Re: Netflix Expansion – Vendor Support 1 (Production Support Services Building)
Erosion and Sediment Control Plan
Engineer's Stamp Date 12/28/2023 (R16E3006AA)

Based upon the information provided in your submittal received 1/4/2024, the above referenced ESC Plan cannot be approved until the following comments are addressed.

ESC-1

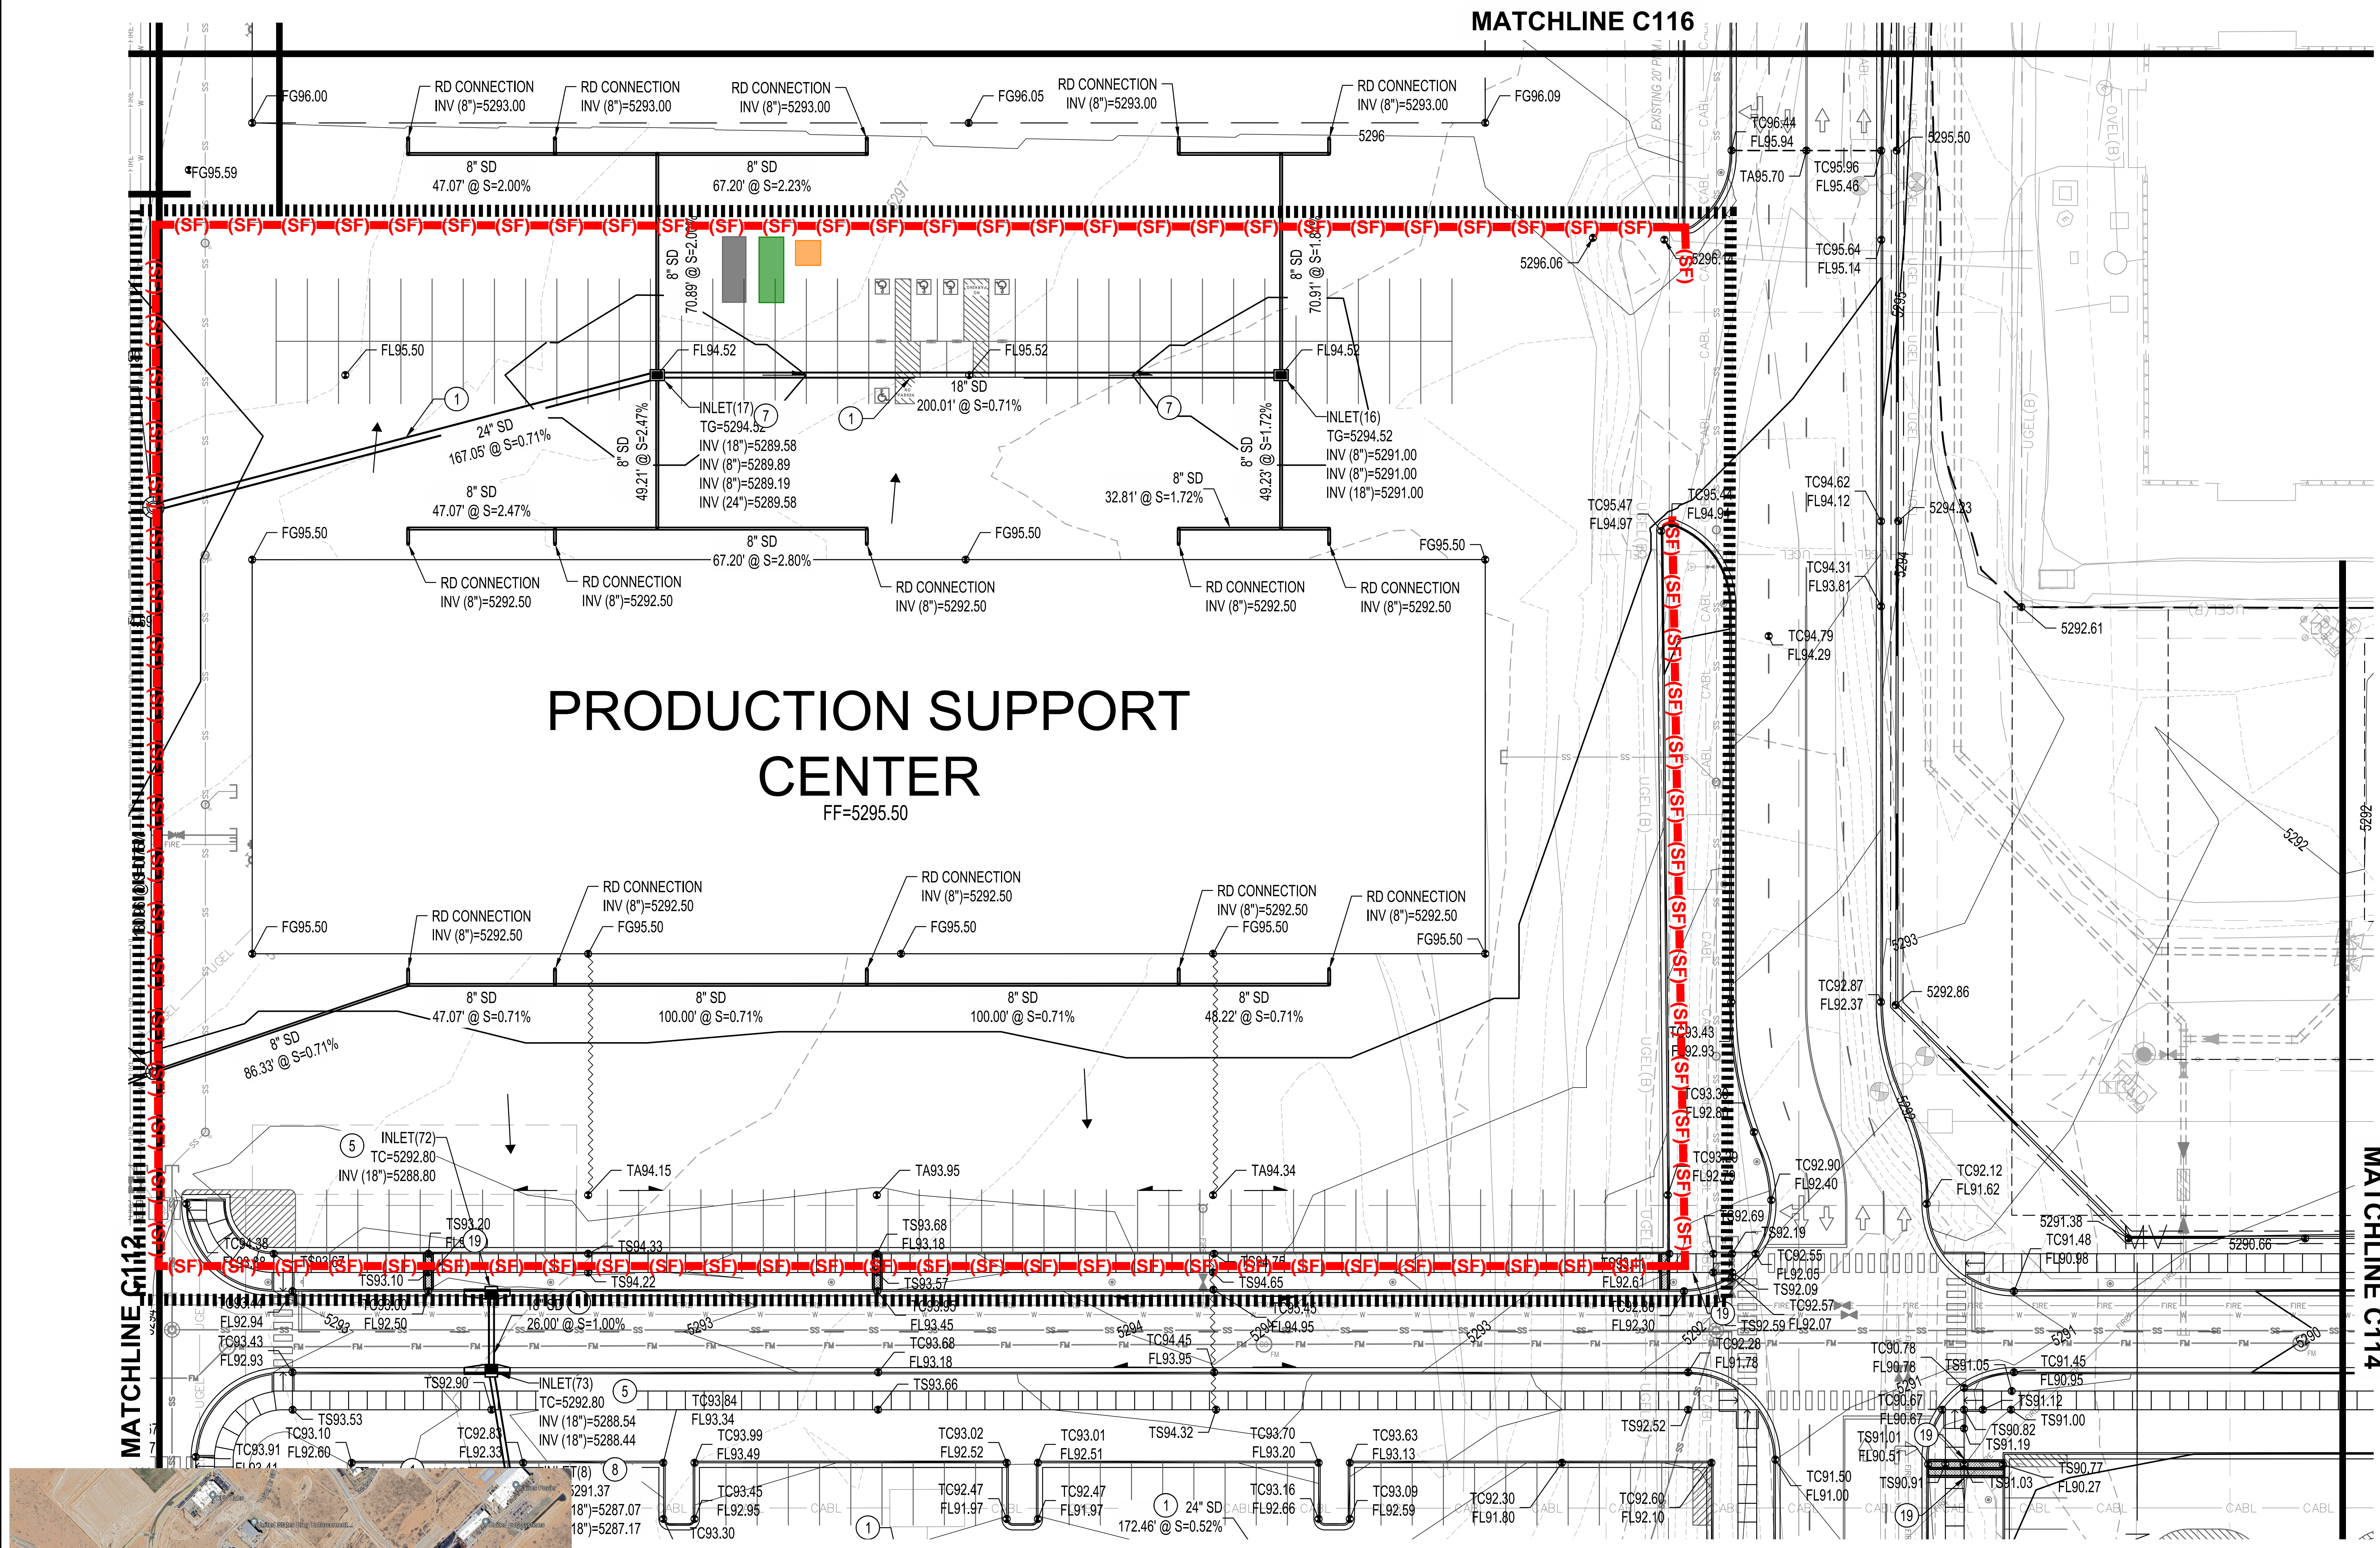
1. The ESC Plan Map does not match the location marked on the Vicinity Map. Add a zone atlas map clearly indicating location and street names.
2. I can't tell the difference between building, sidewalk, asphalt, and dirt on the ESC Plan. These structures must be clearly identified in the SWPPP per CGP 7.2.4.b.vi. The same information is required in the ESC Application. You may attach a copy of the Site Plan to both the SWPPP and the ESC Application to address this requirement.
3. Update the engineer's stamp date each time the plan is changed.
